From: Hebe Smith
Sent: 25 September 2025 13:23
To: Planning.Responses
Subject: FW: Application Y/55/25/HH - Sunnymead, North End Road
Attachments: 646 101 PROPOSED SITE AND BLOCK PLAN REV A.pdf; 646 201 PROPOSED PLAN AND ELEVATIONS REV B SK.pdf; Action Sheet v4 Electronic Version Y-55.docx

Subject: Application Y/55/25/HH - Sunnymead, North End Road

PROPOSED WEST ELEVATION - [1:100]

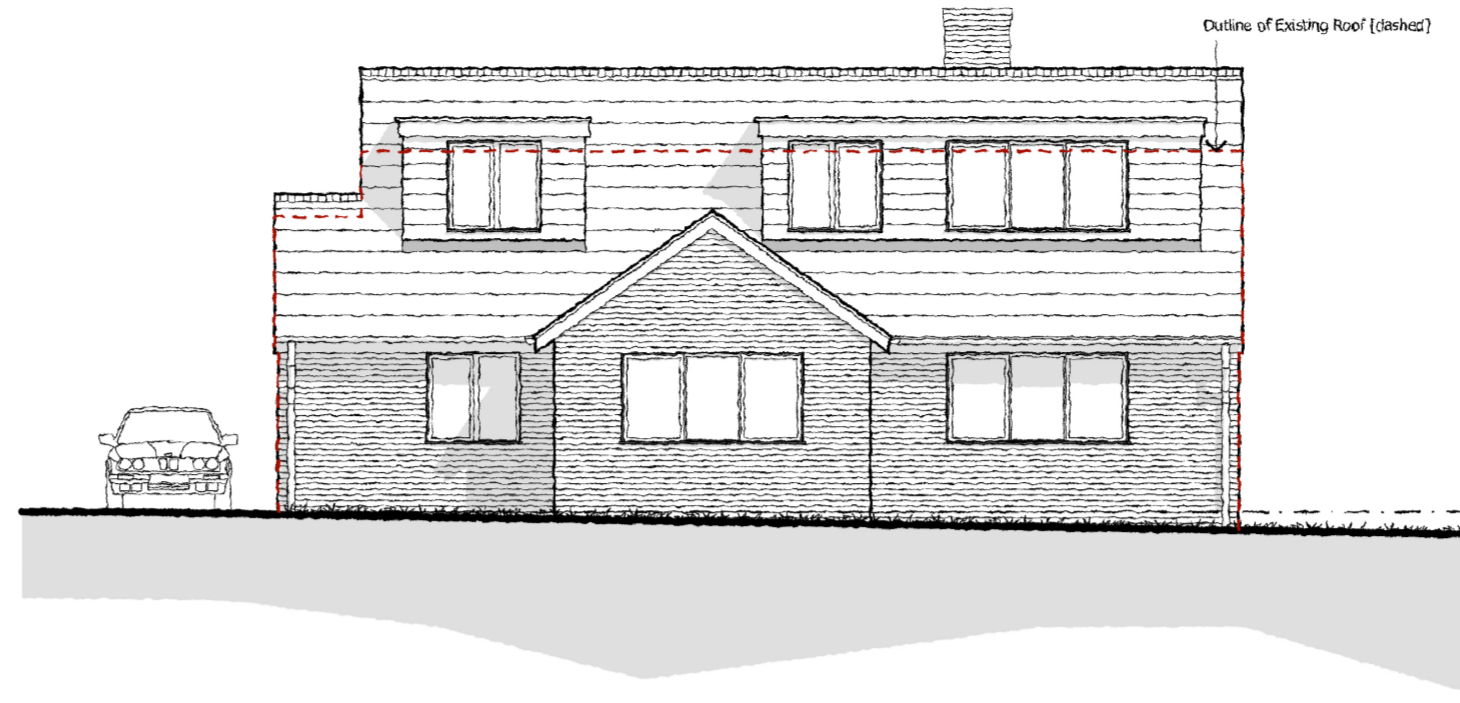
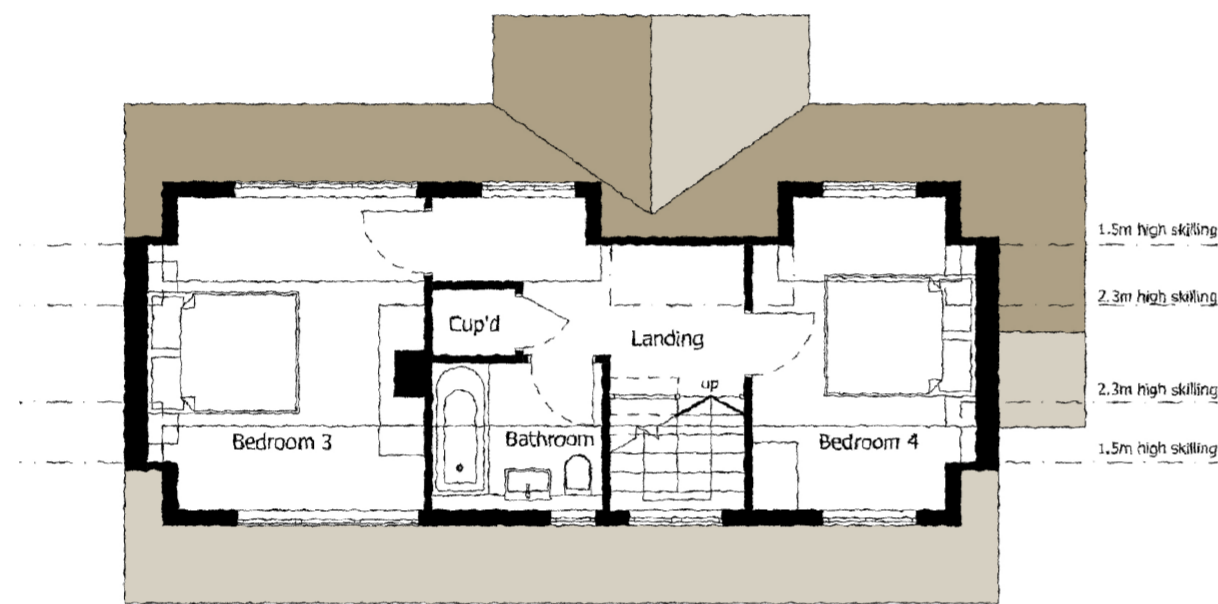
Following consideration of the proposals submitted, I have some concerns about the design of the proposed front dormer. The use of a wide dormer would not be subservient to the main roof form, and I am conscious that alterations to the house would be more visible following the removal of vegetation on the site. Two smaller dormers, preferably with pitched roofs, would be more acceptable in this location.

This could possibly be achieved by removing the front dormer from the two bedrooms, and using two smaller dormers to serve the bathroom and stairs. Rooflights could also be introduced into this front roof slope if required.

I have amended the front elevation, removing the single flat roof dormer and replacing it with 3no. Smaller pitched roofs one to reduce the overall massing [see attached] I hope this will now be acceptable.
